2 March 2022

RESPONSE TO REQUEST FOR INFORMATION - SECTION 4.55(1A) MODIFICATION TO CONSENT – EXPANSION TO THE PINES CARAVAN PARK – 8 HEARNESE LAKE ROAD, WOOLGOOLGA – MP08-0005-MOD 2

HOMETOWN AUSTRALIA
C O M M U N I T I E S

DRAWING TITLE
OVERALL SITE PLAN

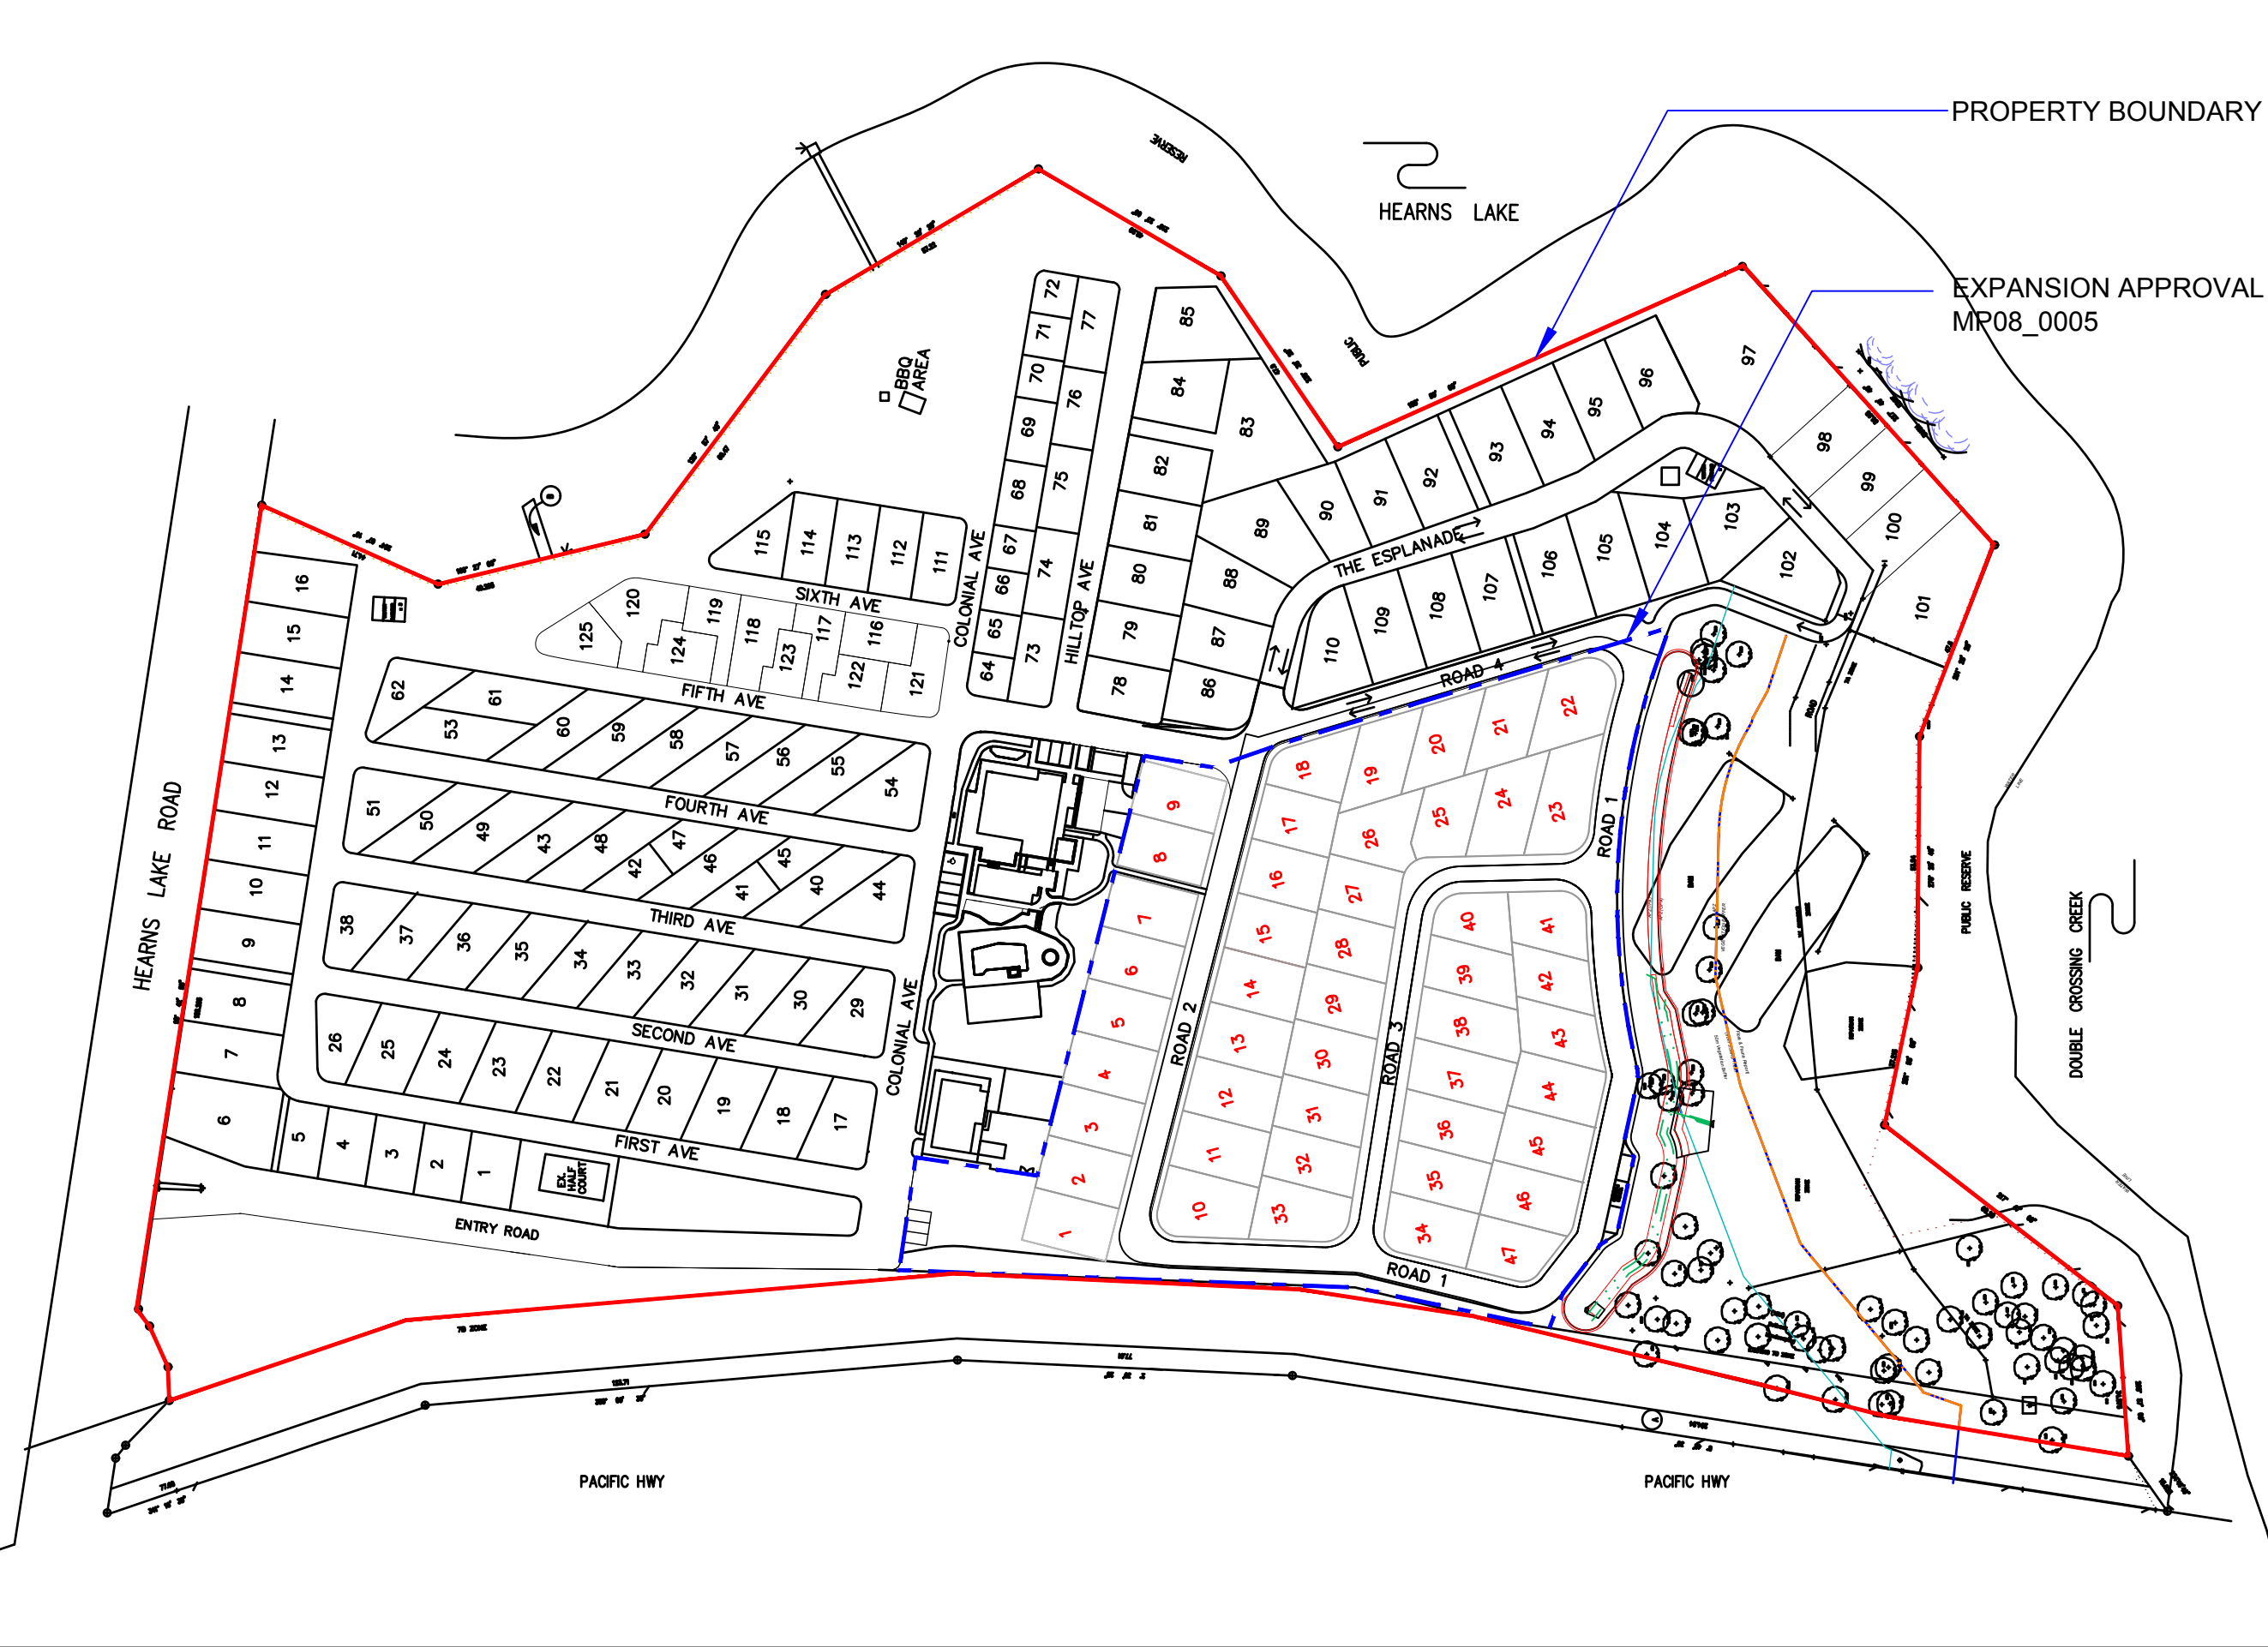
4. The Department is requesting revised Civil Plans (complete set) are provided that identify the extent of cut and fill (as previously identified on 10 November 2021) as well as the revised visitor carparking locations as indicated in your additional information. It is noted that the visitor parking on the Community Plan submitted with MP08_0005-Mod-2 is inconsistent with other documentation, it is requested that consistent documentation be provided.

- A complete set of revised Civil Plans identifying the extent of cut and fill and revised visitor parking locations.
- An updated 'Community Map' including all visitor parking and is now consistent with other documentation.

DRAWING NUMBER  
**MP01**

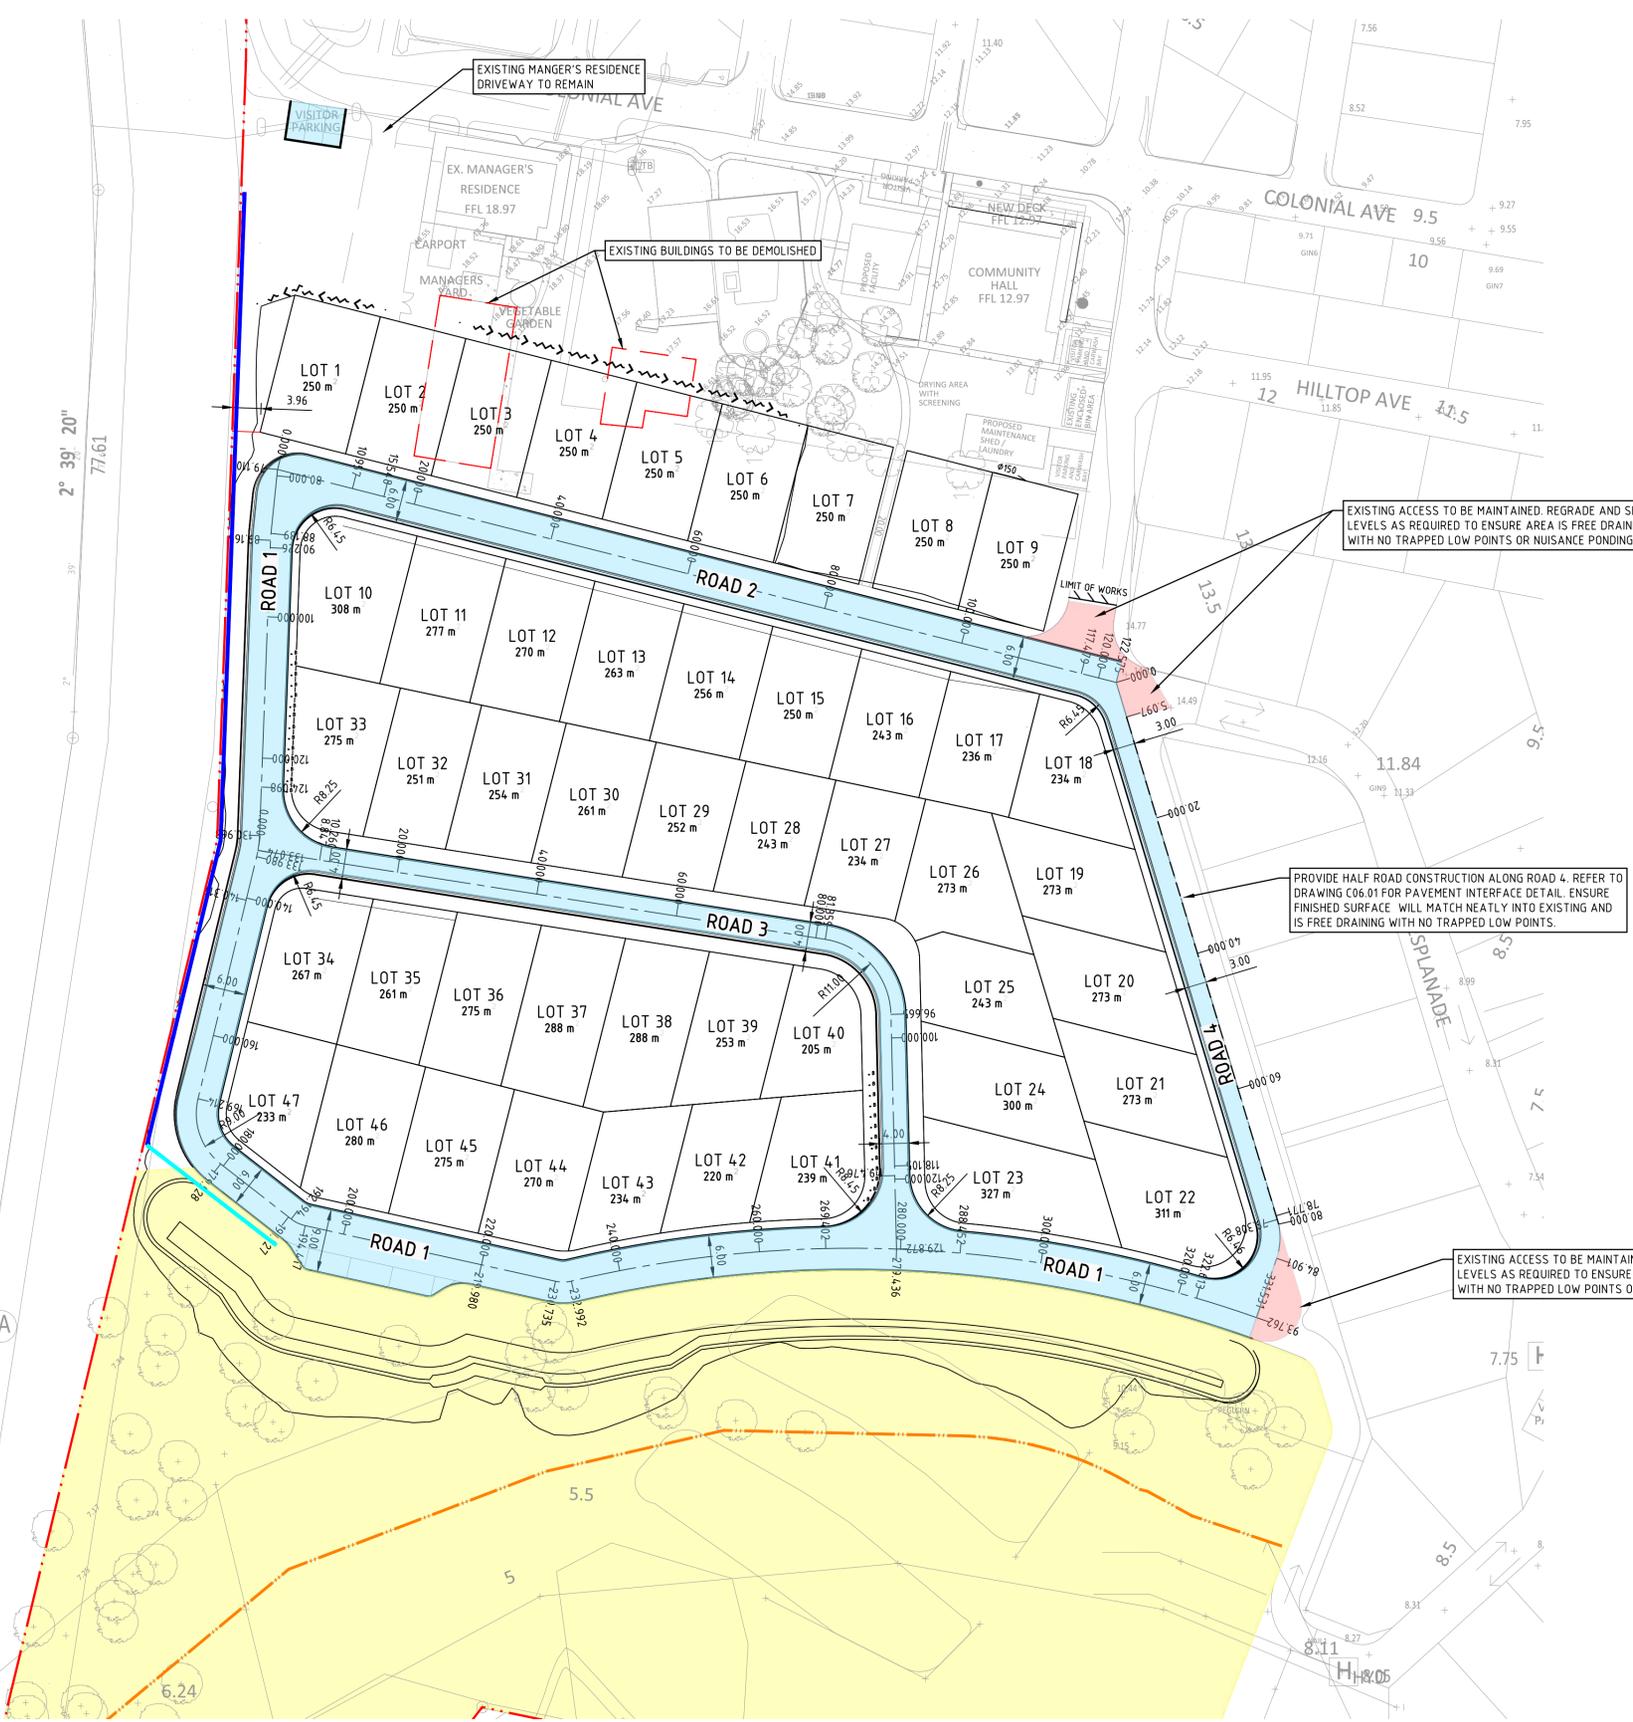
2. The Department requested confirmation of the demolition of structures within the area of sites 1 to 9. In the submitted Response to Request for Information it is unclear whether the structures have development consent for their demolition.

‘Please find attached an updated Site Master Plan (MP01; Rev 1) by Northrop, confirming the structures to be demolished. These structures will be demolished irrespective of the proposed changes i.e. the proposed modification does not introduce new demolition works.’

The Department seeks confirmation that the structures have approval for demolition. If approval has not been sought or granted, the demolition can be incorporated into the proposed modification if required.

Response: Demolition approval has not yet been granted for the structures. Given the demolition works are necessarily associated with the approved development; HTA requests the works be incorporated into the proposed modification. The following images show the original approved plan (Consent dated 4 June 2012; MP08_0005) and the current Master Plan (top and bottom image respectively). By way of comparison, the buildings require demolition in both the original Consent and the current proposal; therefore, the inclusion of the demolition works is not substantially different to the original Consent.
